Recommendation Report for Planning Permission for Works or Extension to a Dwelling

REF NO: AW/30/20/HH

LOCATION: 3 Ely Gardens
Aldwick
PO21 3RY

PROPOSAL: Single storey extension to rear of bungalow.

Proposed Ground Floor Plan

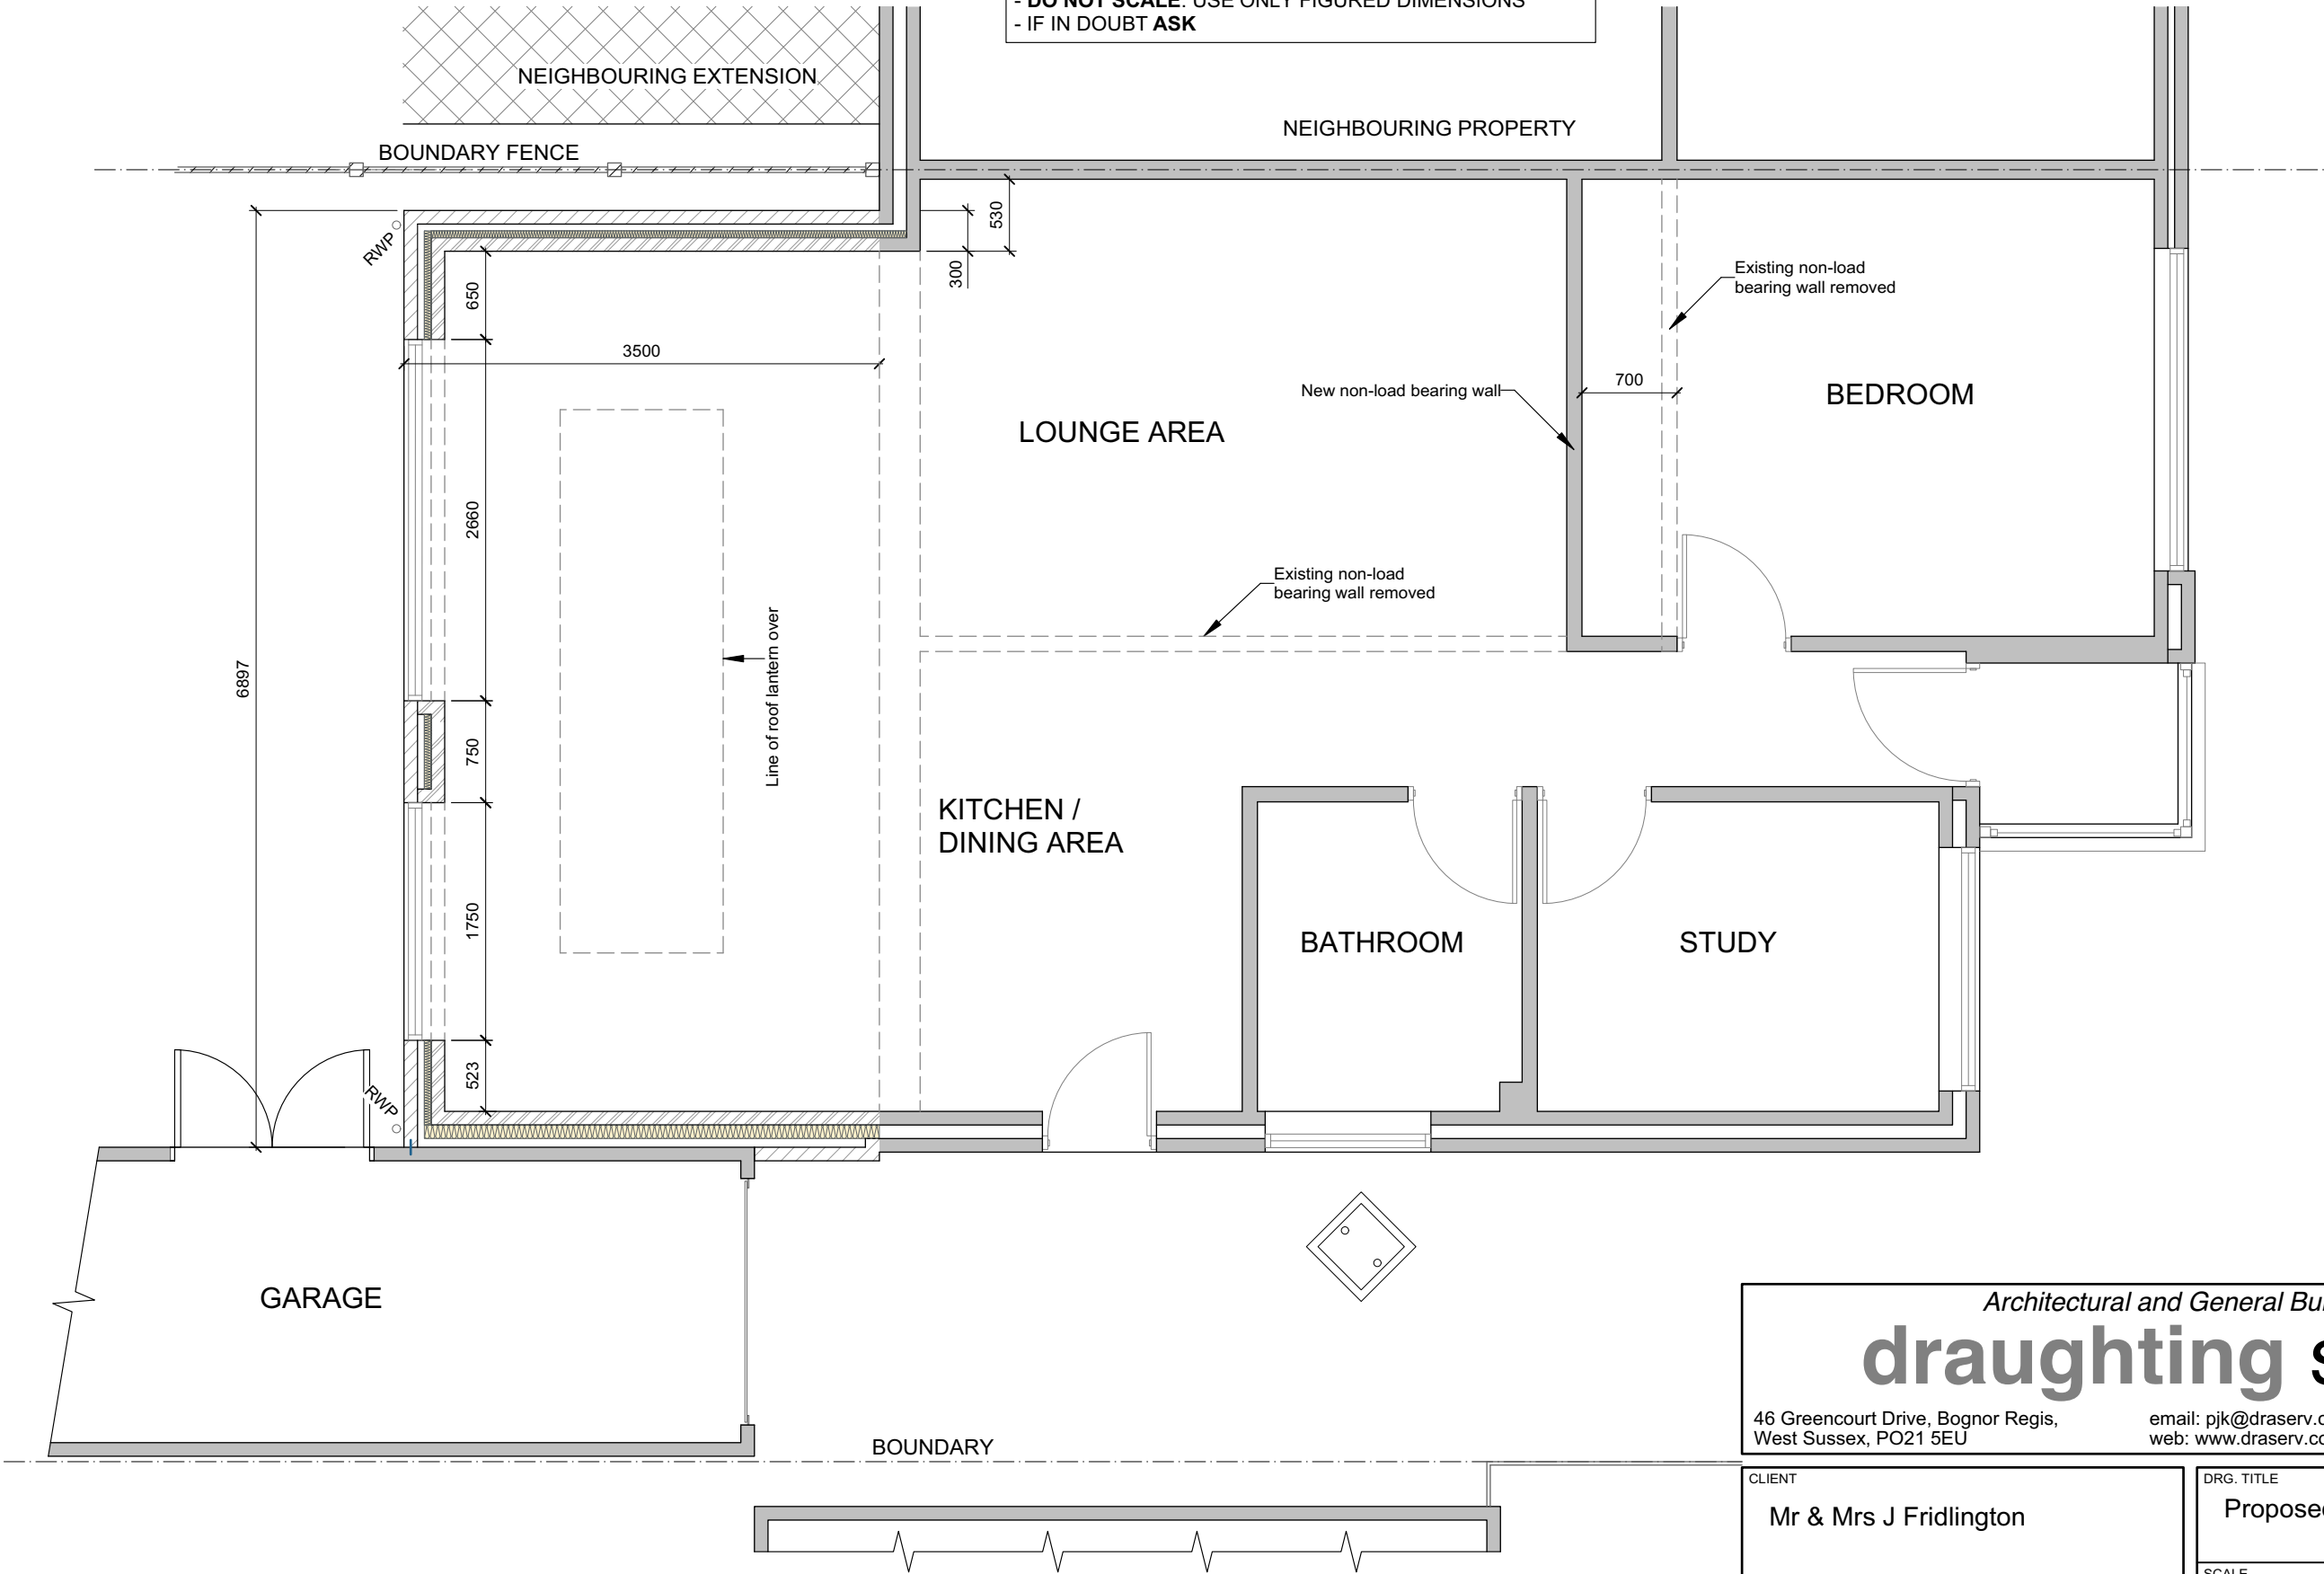
The extension will run along the full rear elevation retaining approximately 0.5m to the western boundary. It will have a depth of 3.5m with a height of 3m. The extension will have a roof lantern to the centre with a maximum height of 3.4m.

There are no windows to the side elevation and with doors opening to the rear garden, it is not considered to result in adverse overlooking.

PROPOSED SOUTH ELEVATION

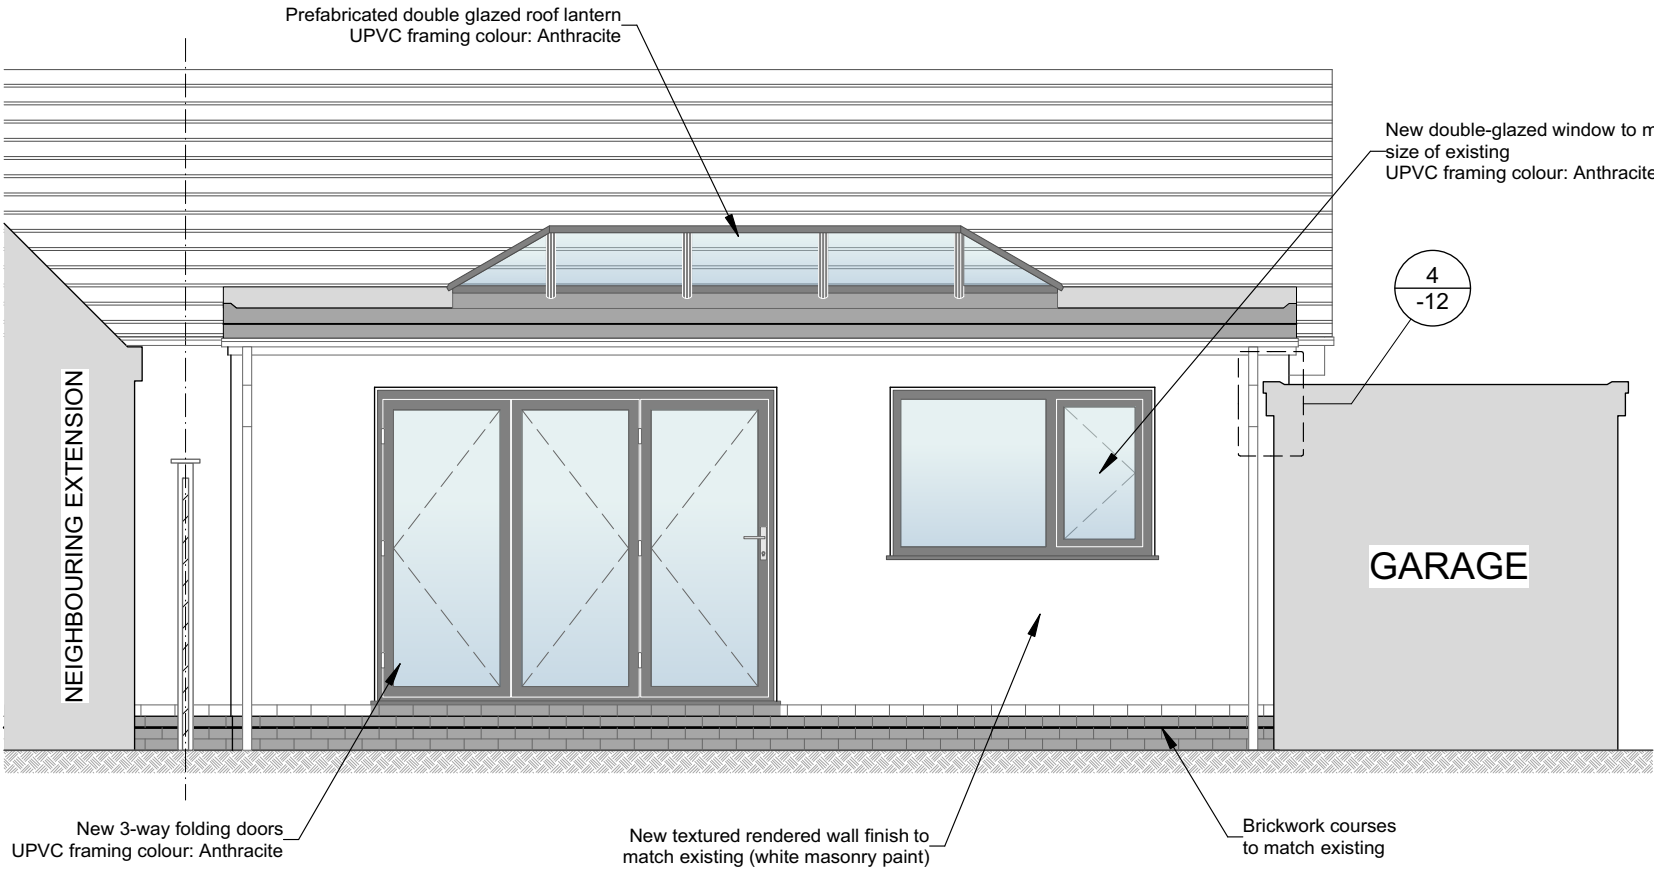
To the neighbouring property at No.5 there is a conservatory and as a result the eastern elevation may have the potential to suffer slight loss of light due to the siting of the proposed extension which is brick in construction. However the application that has been submitted is the same as a previous which required neighbour consultation in which no representation was received and it is considered there was no objection to the works.
